Planning Application Ref: FG/73/18/T

Location: 33 Ocean Drive, Ferring

Description of works: Reduce radial crown spread of 1No. Sweet Chestnut by 3m North aspect

Plan 1

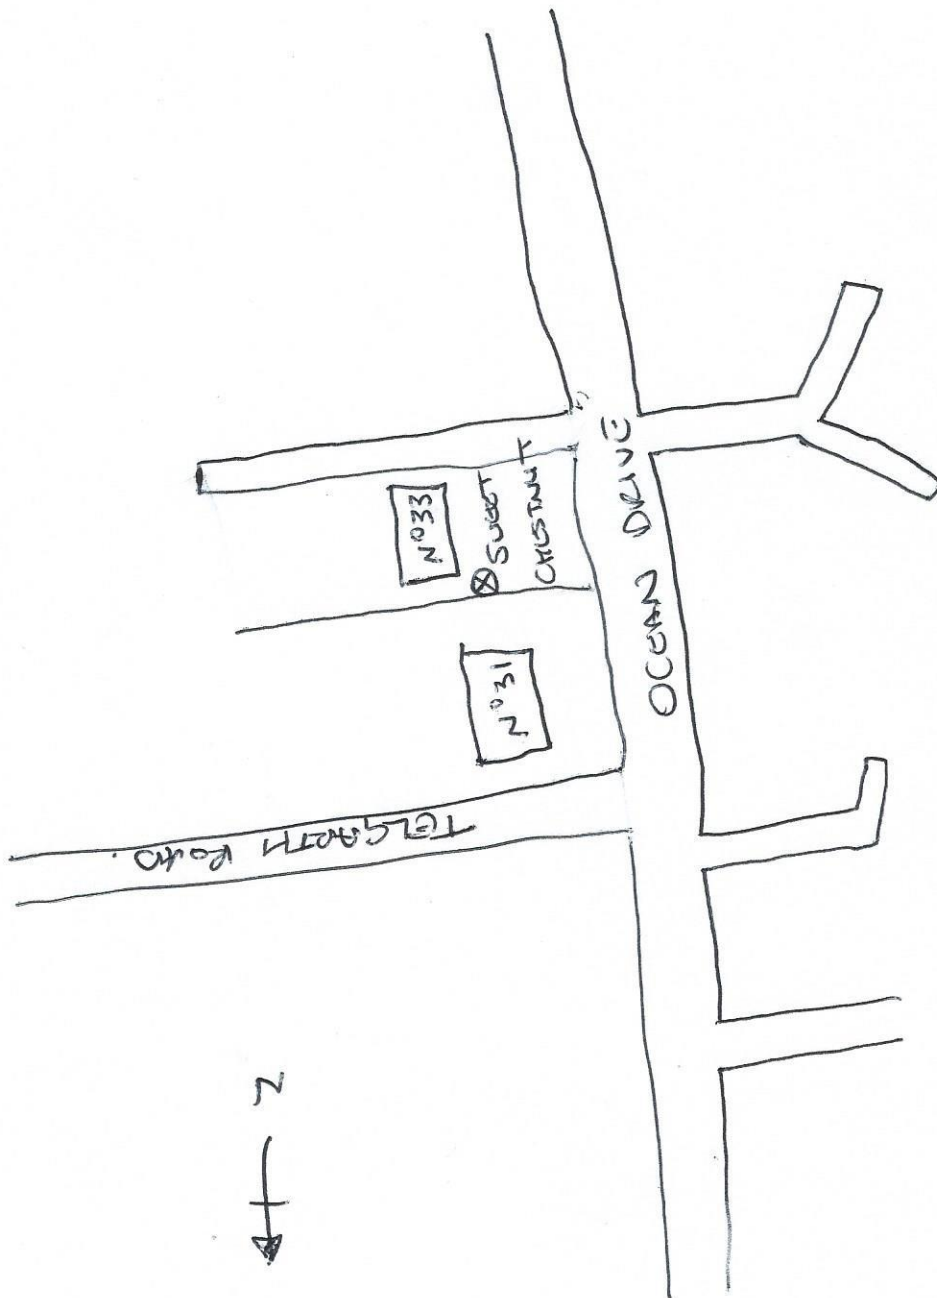
- The plan provided with the application shows the approximate position of one tree, where three are present in a close grouping. This leaves some room for ambiguity, although there is a logical interpretation which can be made, hence my description of the one tree proposed work above.
- The group is highly visible to traffic and adjacent properties.
- Outwardly they appear to be in a fine physiological state. Crown form is moderate and they benefit from group cohesion at such an exposed location. Previously 'lopped' at around 7m height.
- The work proposed involves the approximate reduction of half the North radial spread (overhanging 31 Ocean Drive).
- The removal of dead branches is an exception and does not require permission.

- I recommend **CONSENT** for this application, subject to the following condition:

- Where whole branches are to be removed and final cuts made close to the trunk or branch union they are to be made as shown in Figure 2 of BS3998:2010
- Where branches are to be shortened back the final cuts are to be made at the correct angle shown in BS3998:2010 and adjacent to a live bud or lateral.
